Reference 3/2024/0606
Location 16 Sutherland Close Wilpshire BB1 9LT
Proposal Proposed removal of existing timber annexe and replacement with single-storey, detached garden room

Lancashire County Council Public Rights of Way Team raises no objection to the application and provides the following.

## 16 Sutherland Close, Wilpshire, Blackburn, BB1 9LT

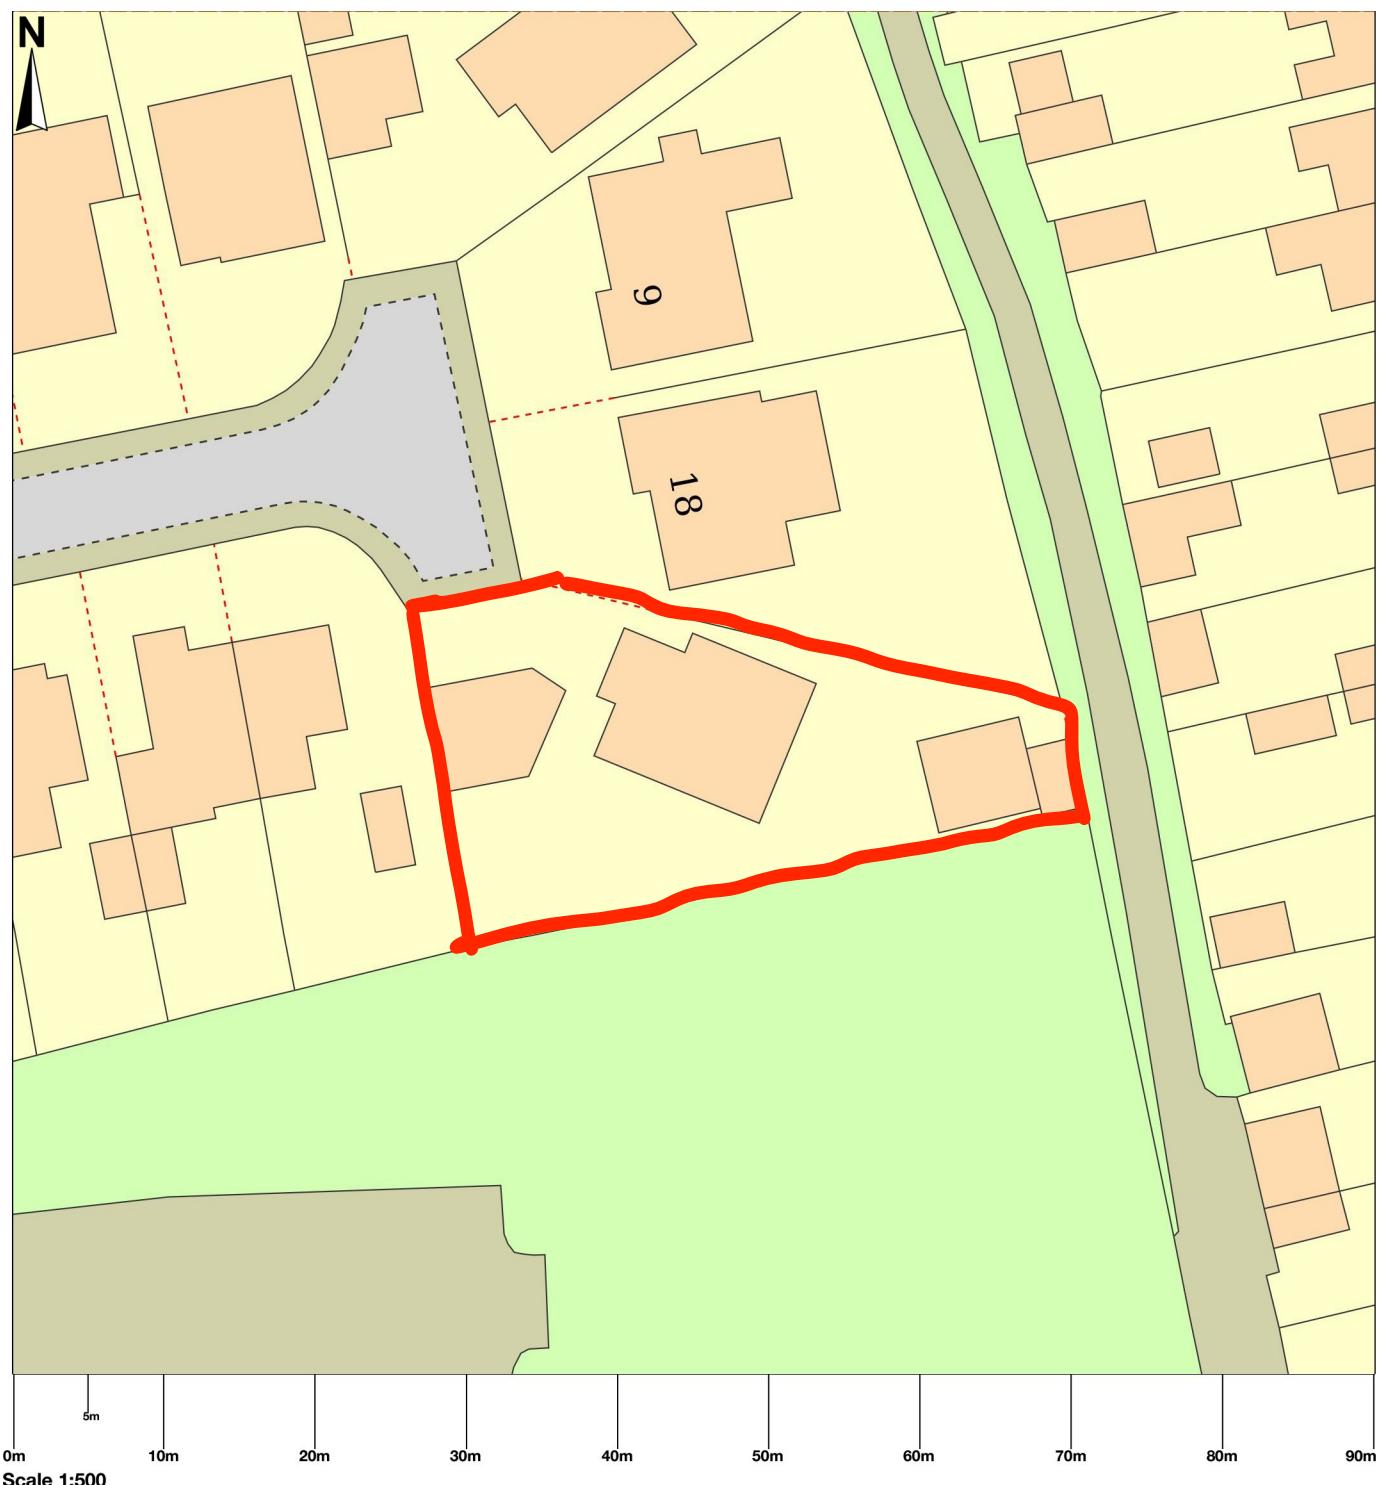
Footpath FP0346007 is recorded as running along the eastern boundary of the property, as shown on the attached plan. Any obstruction of the existing public rights would be a criminal offence, as such the detached garden room must not encroach reducing the existing width of the footpath.
